**RE: Custom Home**  
**2216 Ana Ct NW**  
**Grading and Drainage Plan**  
**Engineer's Stamp Date: 12/08/25**  
**Hydrology File: H11D012A**  
**Case # HYDR-2025-00462**

Based upon the information provided in your submittal received 12/30/2025, the Grading & Drainage Plans **are not approved** for Grading Permit or Building Permit. The following comments need to be addressed for the approval of the above referenced project.

GRADING & DRAINAGE PLAN

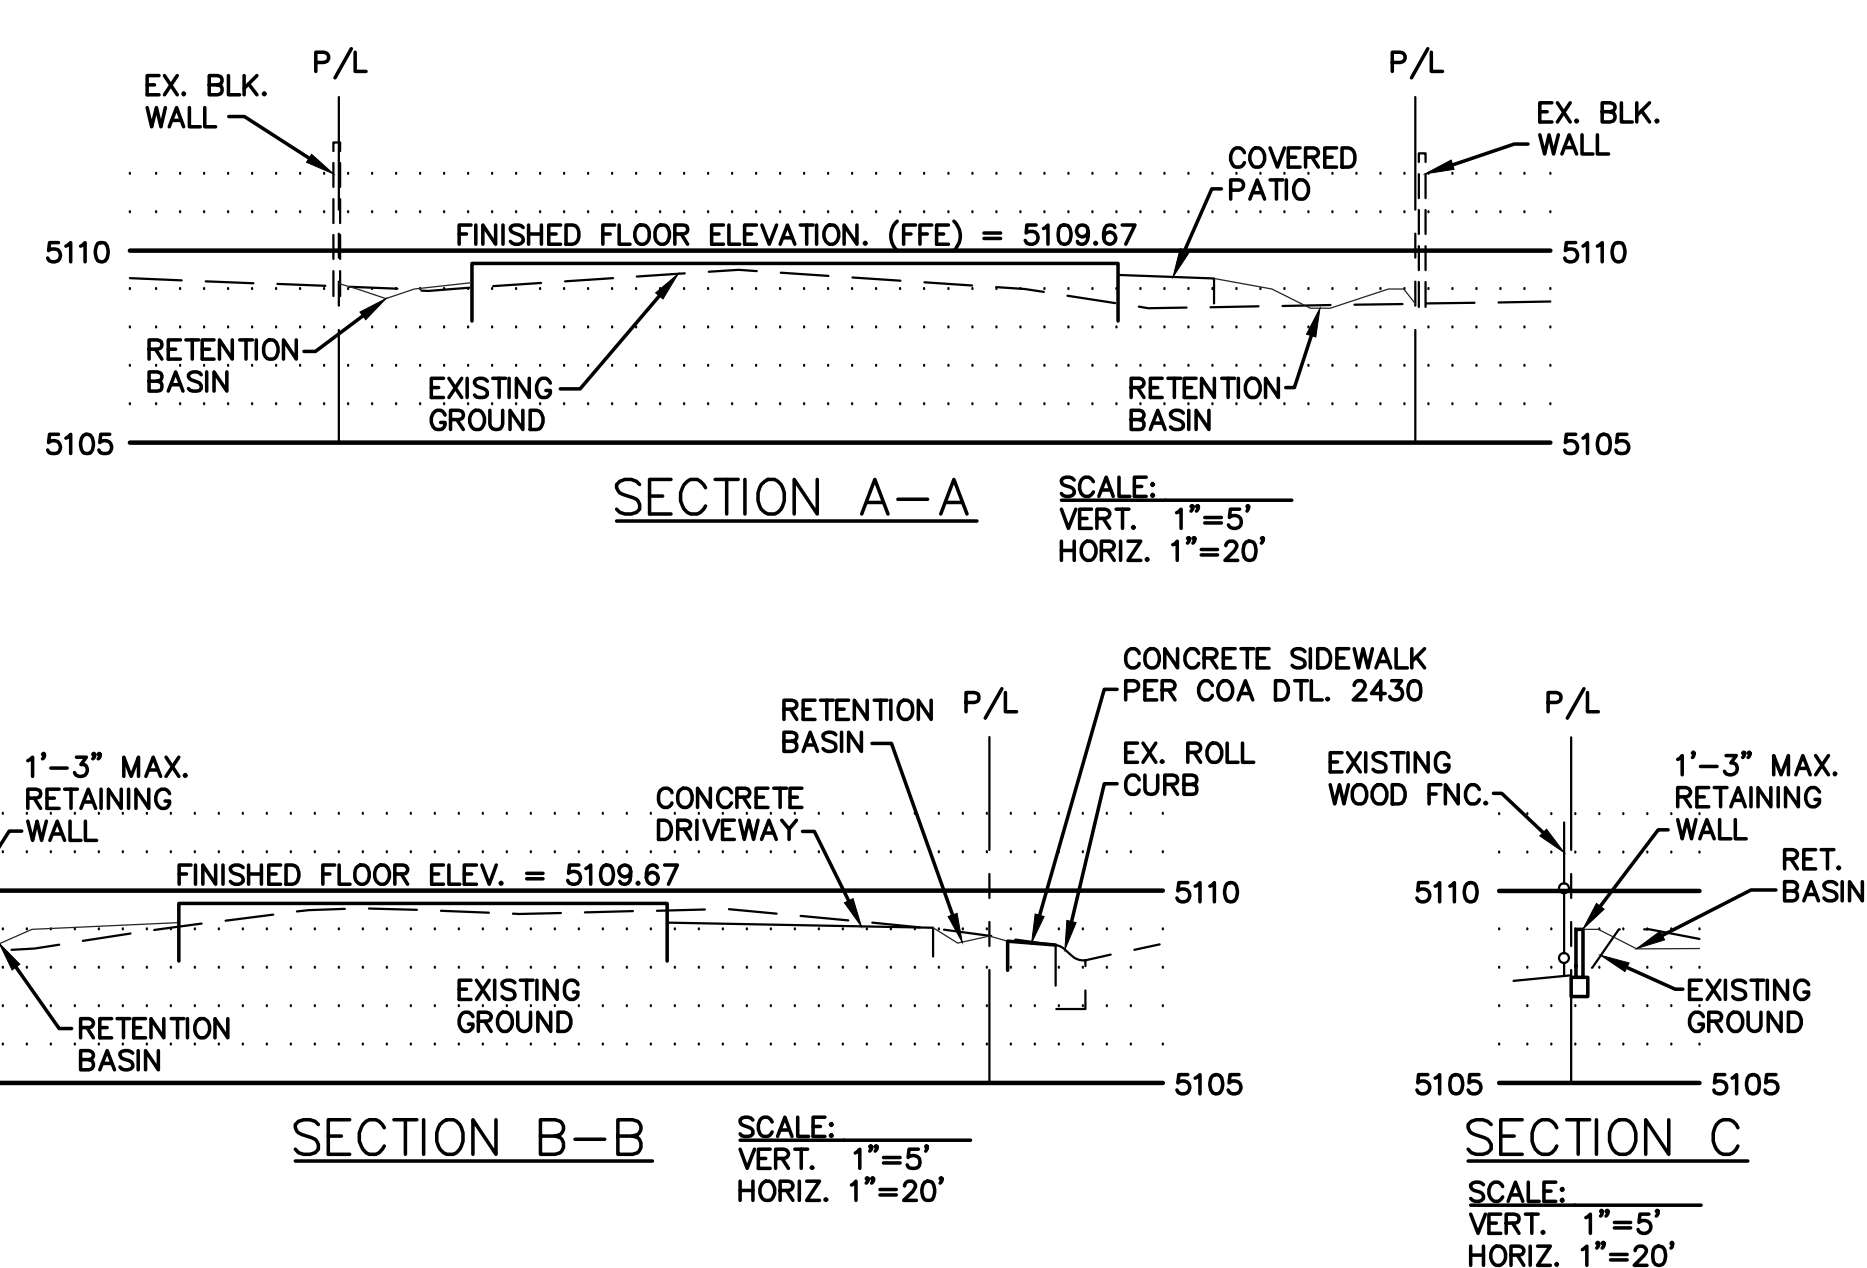
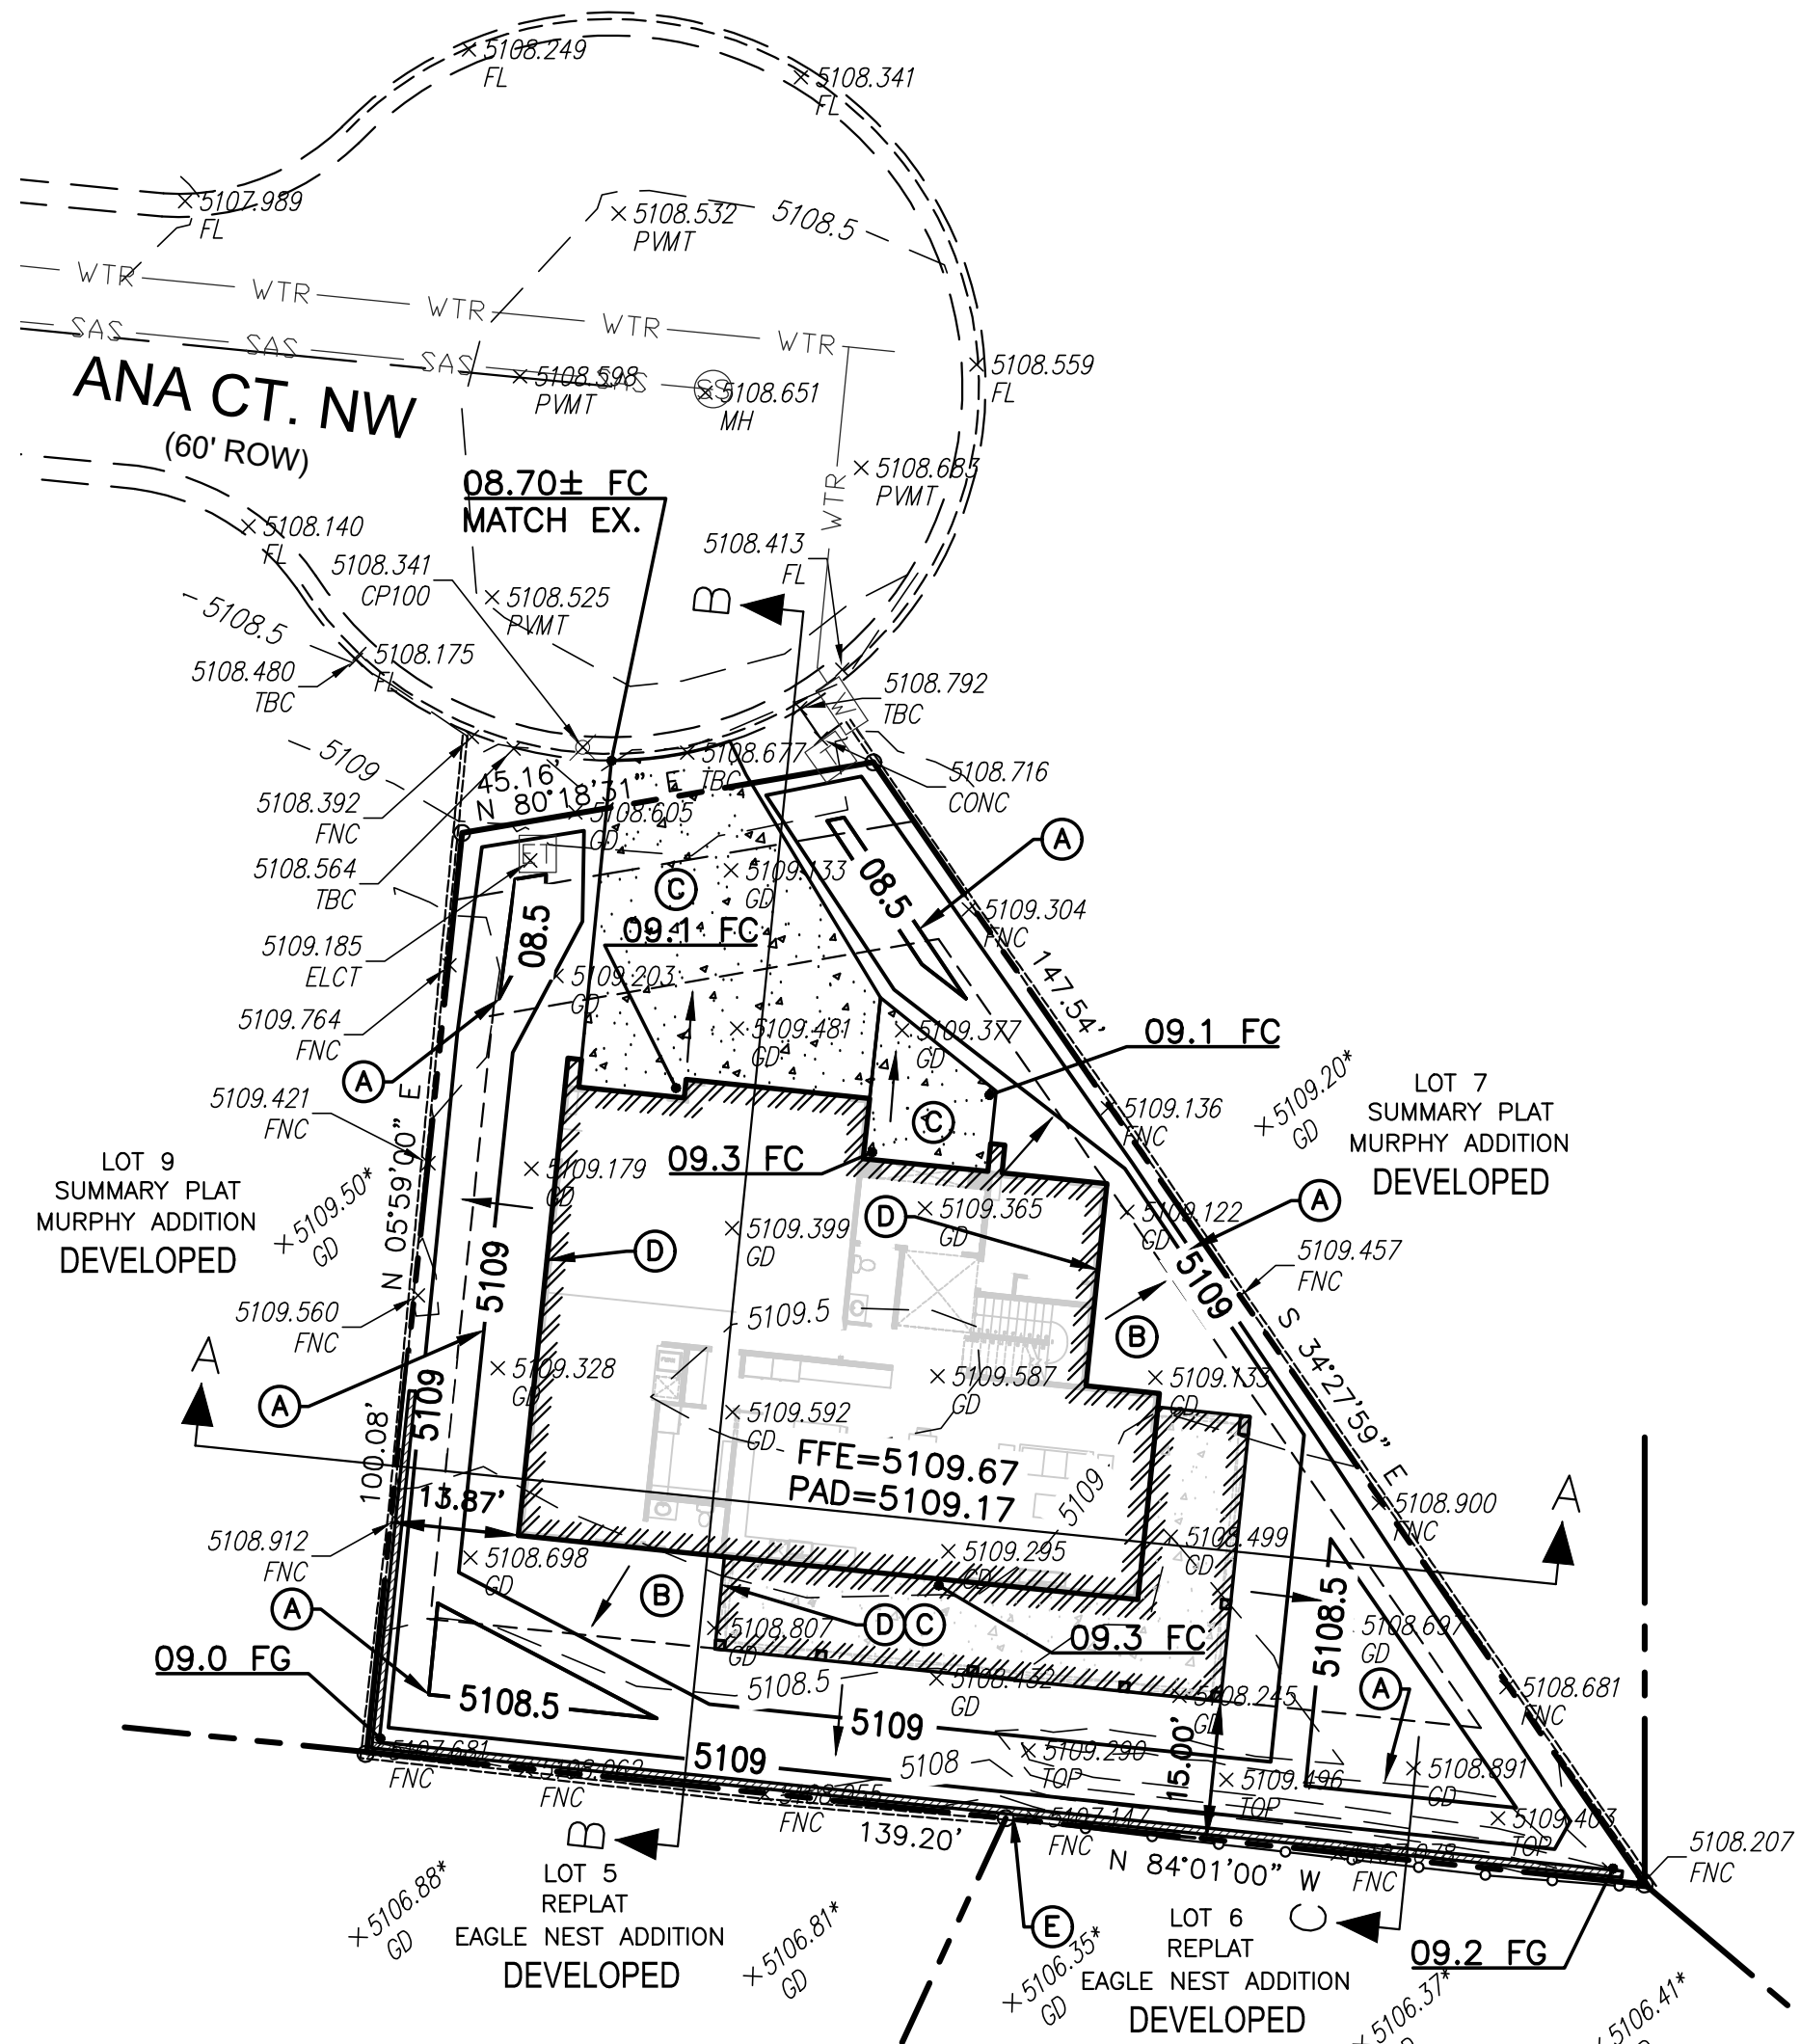
1. Per the IDO, the property owner of the property is responsible for building the adjacent half of Ana Court NW to include curb & gutter, **and sidewalk**. The project will have to go to the Development Facilitation Team (DFT) for approval of the Infrastructure List. Please show the sidewalk on the plan.
2. The SE corner of the site has an existing wood fence that will not control stormwater from crossing the property line. Please show a block wall to contain the stormwater to the site.

3. Provide the existing and proposed grades on both sides of any existing and proposed walls.
4. Provide sections through all external boundaries showing proposed retaining walls, garden walls, property/ROW lines, existing and proposed grades. In accordance with DPM Ch.22, section 5 part B, grading and wall construction near the property line may not endanger adjacent property or constrain its use
